COMMENT OF SEPA THRESHOLD DETERMINATION

Kittitas PUD #1 Headquarters SE-26-00003

Subject Parcel: #051833 4271 Kittitas Hwy, Ellensburg, WA

Applicant: Manastash Architecture Planning and Development (MAPD)

C1.0

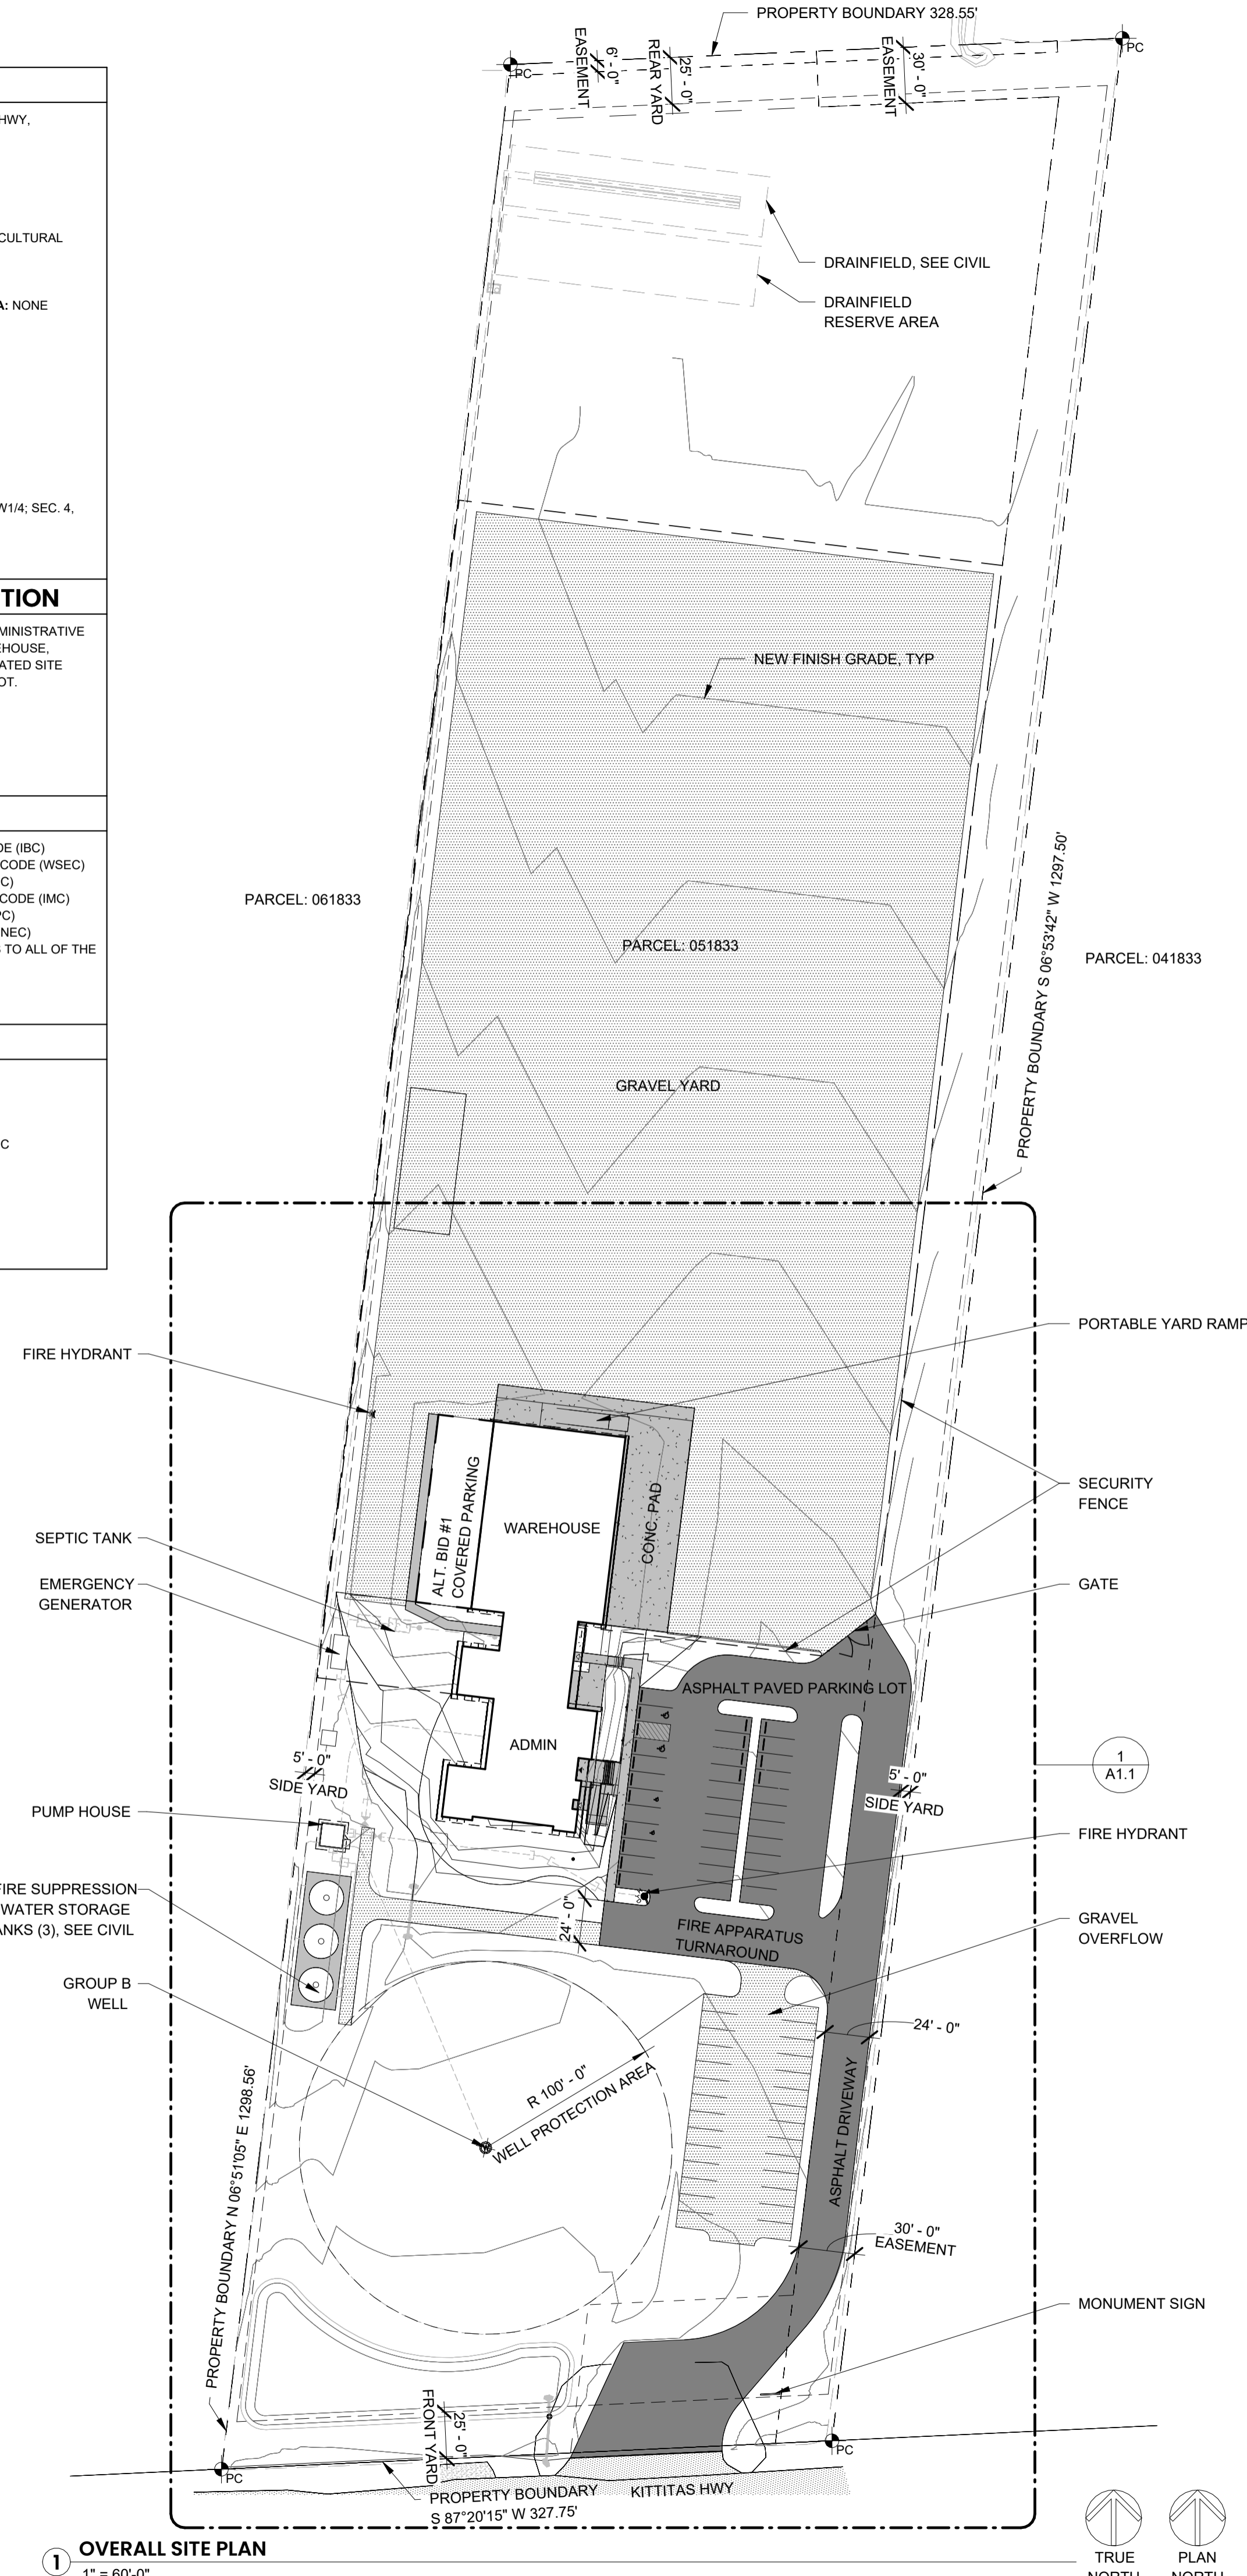
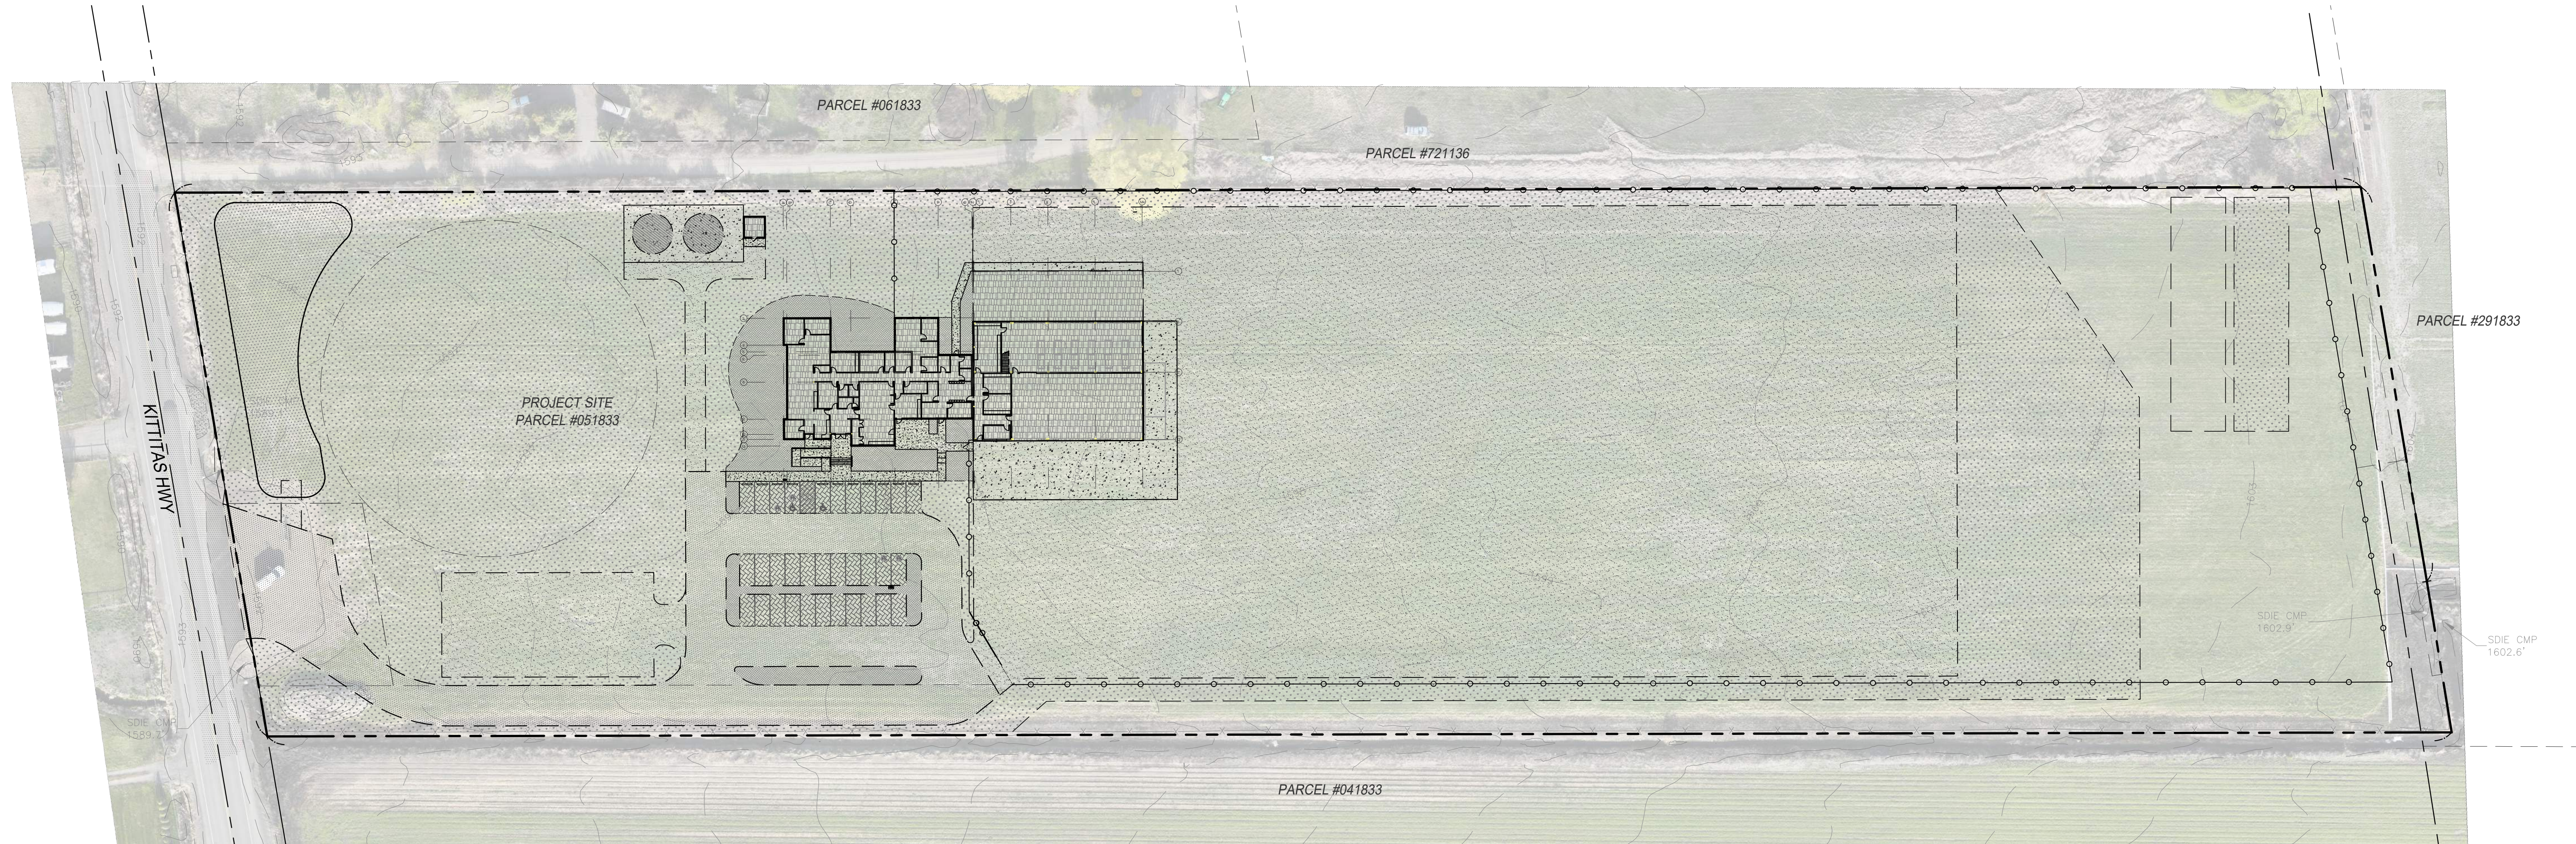
Checklist §B.7.a(3) states “no anticipated hazardous chemicals will be stored, used, or produced.” The site plan (Exhibit E) confirms three 60,000-gallon fire suppression tanks—180,000 gallons of dedicated fire water. Under NFPA 22, tank capacity must “reflect actual fire demand.” That volume is consistent with a facility storing transformer mineral oil (a Class IIIB combustible liquid), diesel fuel, hydraulic fluids, and potentially PCB-containing equipment—not a low-impact administrative office. The Group B well at 275 gpd would take approximately 655 days to fill the three tanks; the water source for the fire system is not disclosed. Analyzed in Section VIII. Controlling authority: Norway Hill Preservation & Protection Ass’n v. King County Council, 87 Wn.2d 267 (1976) (hard-look standard); Ellensburg Cement Products, Inc. v. Kittitas County, 179 Wn.2d 737 (2014) (DNS reversed for industrial use on A-20 in this same County).

Checklist §B.8.b and §B.14 contain no analysis of impacts to adjacent active agriculture. The site plan narrows Farmer Stakeholder’s 30-foot easement to a 25-foot paved strip, pinches the northeast corner with a rigid fence, and ignores an adjacent irrigation ditch that RCW 7.48.310(1) expressly identifies as part of a protected agricultural activity. Analyzed in Section V. Controlling authorities: *Zonnebloem, LLC v. Blue Bay Holdings, LLC*, 200 Wn. App. 178, 184 (2017) (“actions that make it more difficult to use an easement . . . are prohibited . . . unless justified by the needs of the servient estate”); *Buchanan v. Simplot Feeders Ltd.*, 134 Wn.2d 673, 680 (1998) (Right to Farm three-part test); *Thompson v. Smith*, 59 Wn.2d 397, 408–09 (1962) (easement balancing test).

The site plan (Exhibit E) allocates zero acres of the 9.65-acre parcel to designed greenspace, landscape buffers, working agriculture, or native vegetation. The dominant land use is a 5.79-acre industrial gravel yard (60% of the parcel) with no visual screening between the PUD operation and Farmer Stakeholder’s adjacent active hayfield, no street-frontage landscaping along Kittitas Highway, and no internal vegetation of any kind. The 30-foot agricultural easement along the eastern boundary is encumbered land within the PUD parcel that cannot be counted as project greenspace under any methodology. By contrast, a typical single-family residence on a comparable 10-acre rural parcel in Kittitas County leaves 80–90 percent of the ground in a combination of pasture, hay, garden, ornamental landscape, trees, and native vegetation—the configuration the County’s comprehensive plan designates as “Rural Working.” A site plan with zero greenspace cannot satisfy the comprehensive plan’s “Rural Working” designation, the GMA’s open-space and natural-resource goals at RCW 36.70A.020(8)–(10), or the KCC 17.60A conditional-use compatibility requirement that mitigation include “landscape buffers, special setbacks, screening, and/or site design using physical features.” Analyzed in Section V.L. Controlling authorities: WAC 197-11-444 (land use, plants, animals, aesthetics, and recreation as enumerated elements of the environment); RCW 36.70A.020 (GMA planning goals); KCC 17.60A (conditional-use compatibility findings).

Exhibit E (Overall Site Plan A1.0 / C1.0) shows a 6,300 sf administration building, a 10,200 sf pre-engineered materials warehouse, a large fenced equipment and materials yard, two (or three) 60,000-gallon fire suppression water tanks, an emergency generator, a Group B well and pump house, a septic tank with drainfield and reserve area at the north end, a portable yard ramp, and approximately 53.5% total impervious coverage. The project narrative and public notice nevertheless frame the proposal as a low-impact "administrative facility."

Farmer Stakeholder's adjacent parcel contains a known chronically wet area at the terminus of the shared 30-foot easement. Exhibit E locates the primary drainfield and drainfield reserve area at the extreme north end of the subject parcel directly adjacent to this wet zone. Exhibit F (Critical Areas) shows a PSS1A palustrine scrub-shrub wetland and mapped hydrologic features in the immediate vicinity. No hydrogeologic analysis, effluent migration analysis, or seasonal saturation study has been provided.

Exhibit E depicts the PUD’s paved access and circulation surface within the 30-foot easement as approximately 25 feet wide, with a perimeter security fence running alongside the paved strip on the PUD side. Five feet of the recorded 30-foot easement is thereby converted from usable agricultural travel width to an unpaved shoulder pinched between the fence and the paved edge. For a haying operation, that five-foot reduction is not cosmetic: modern haying equipment routinely exceeds 12 feet in transport width, and oversized loads such as stacked bale wagons commonly require the full width of a 30-foot easement plus overhang tolerance to navigate without damage. The checklist does not disclose the actual paved width, the fence setback, the effective functional clearance, or any analysis of whether common haying equipment can operate within it.

Exhibit E shows that the PUD parcel comes to a sharp corner at its northeast boundary along the line where the easement and Farmer Stakeholder's field meet. Agricultural equipment making the turn into or out of the field at that corner routinely overhangs the fence line. A rigid perimeter security fence at that corner, installed tight to the pavement edge, converts overhang tolerance into a hard stop: any implement that extends beyond the tractor profile will strike the fence. In practical terms, the sharp-corner geometry plus a rigid fence on the PUD side closes the turn for any equipment larger than a light tractor. No turning-movement analysis, equipment clearance envelope, or fence placement analysis appears in the SEPA record.
